From: Sue Howell
Sent: 14 December 2017 16:14
To: Michael Eastham
Subject: FW: Planning Consultation on: LU/282/17/RES

Comment from Greenspace

APPLICATION LU/282/17/RES

Site Address: Land North of and South of Railway Courtwick
Lane Littlehampton BN17 7FR

COURTWICK, LITTLEHAMPTON
Changing Facilities

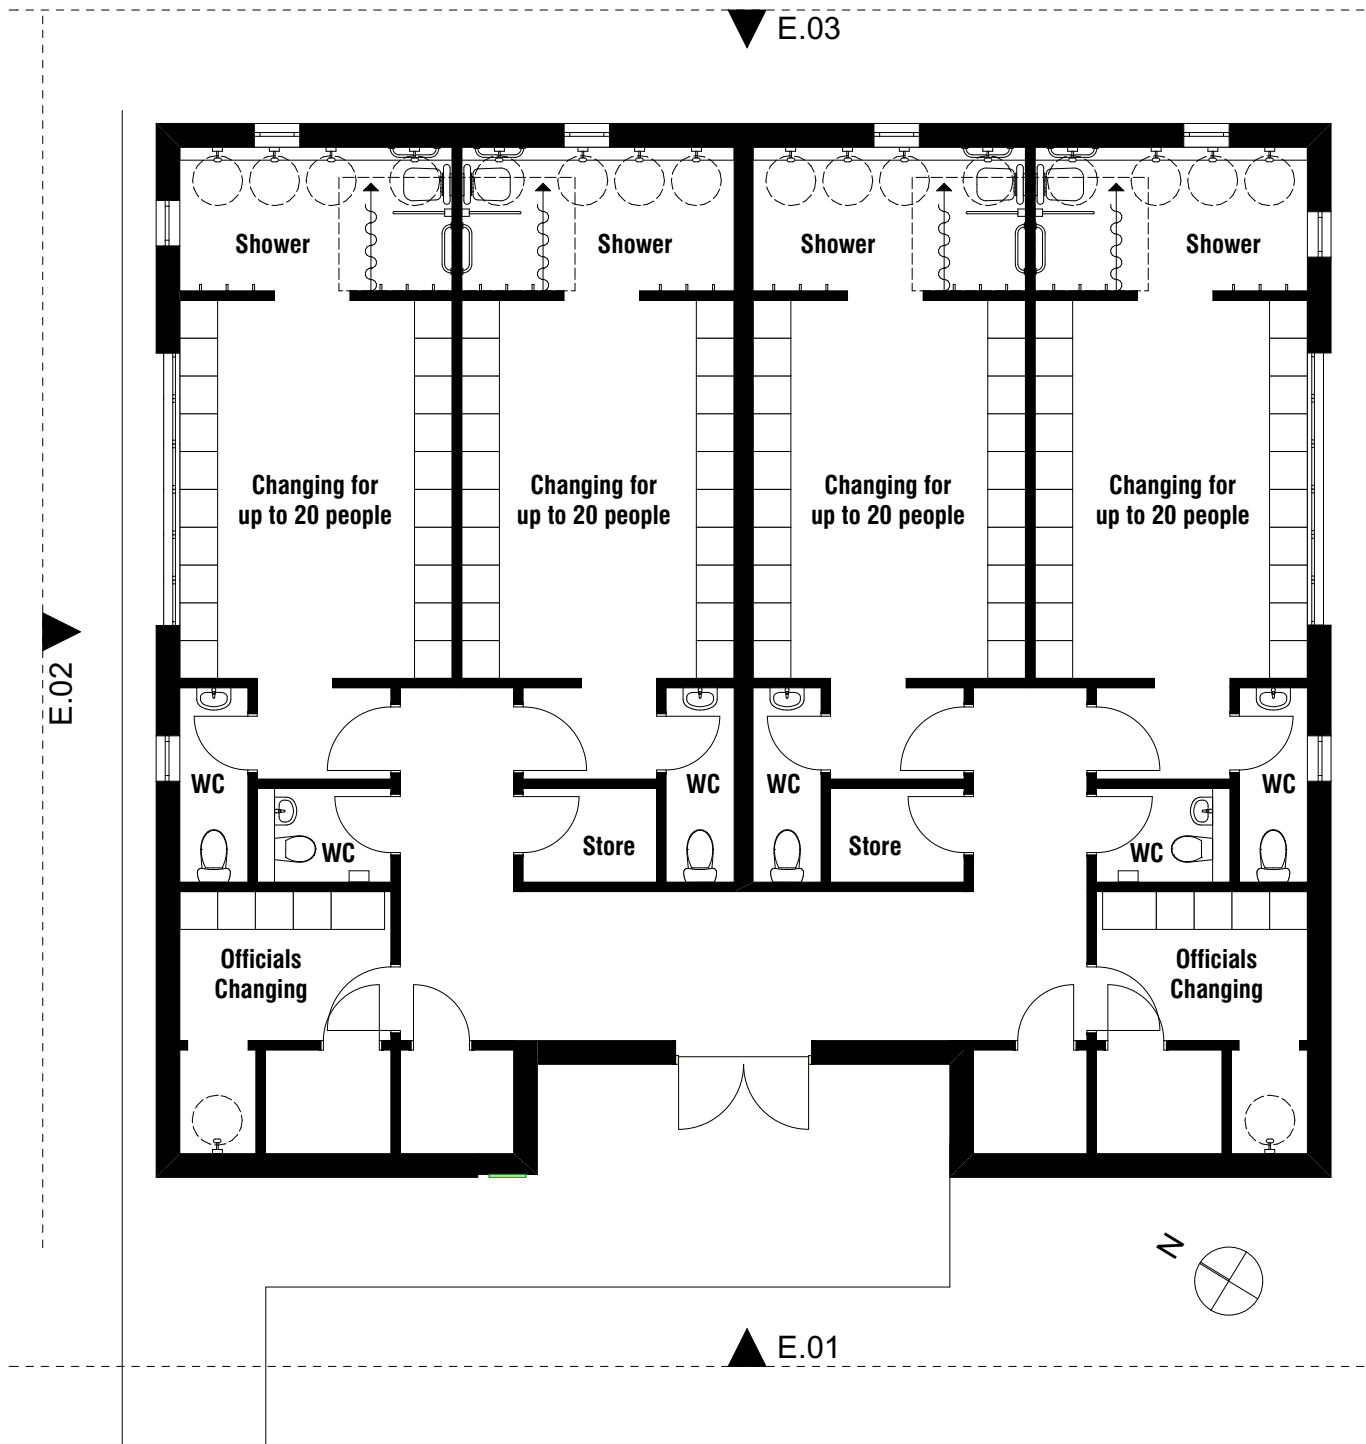
The detail would appear to show a change from the detail supplied at masterplan stage in relation to an element of the POS now to be developed. Whilst the siting of the changing facility is now closer in relation to the proposed sports offer we would require detail in plan form of the landscaping being proposed, showing plant species, density and size at time of planting.

Block Plan

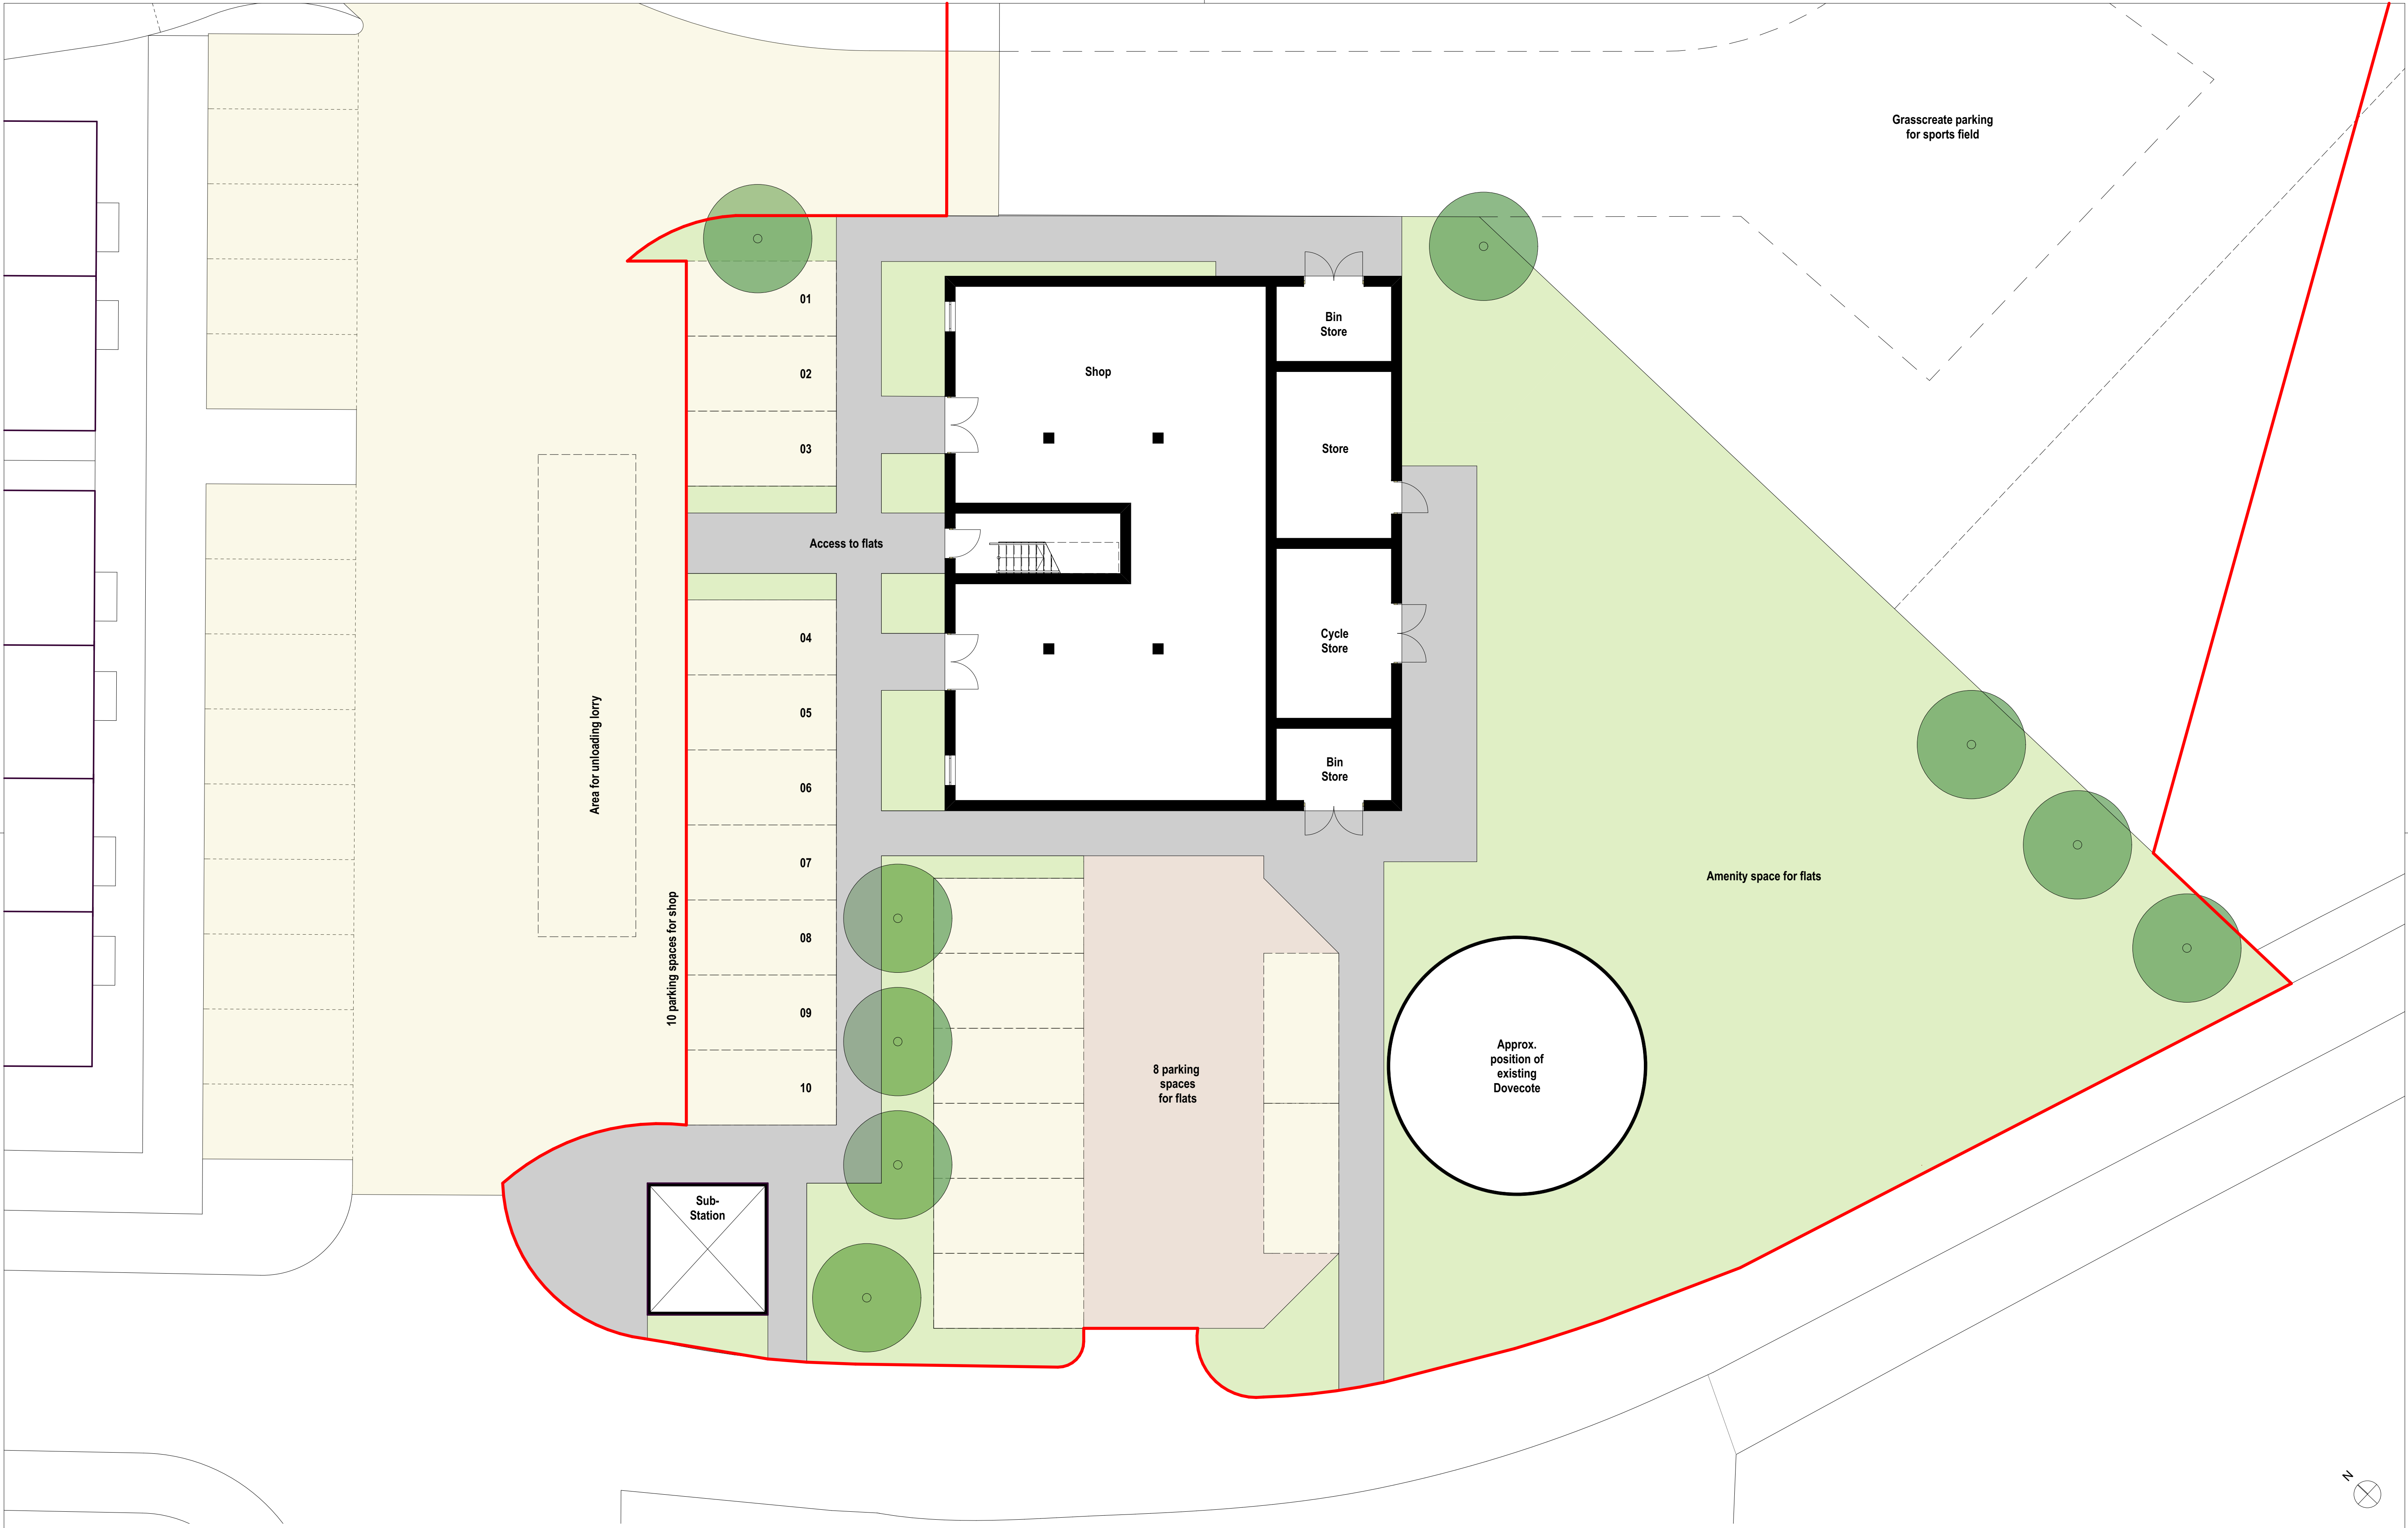
As a point of note regarding a previous query would be to request clarification of parking provision being proposed for the changing facilities ie number of spaces, location and layout of these.

We would require this also for the commercial /residential unit along with confirmation of the parking facilities ie number of spaces and layout, being proposed for both of these.

Further to submission of drawing no 1140/01 Planting plan we can confirm that the detail is now sufficient in plan form showing the landscaping being proposed, with suitable plant species, density and size at time of planting.

The location of LEAP has also now been confirmed which shows location, planting to surround and connectivity to pathways, which is adequate.
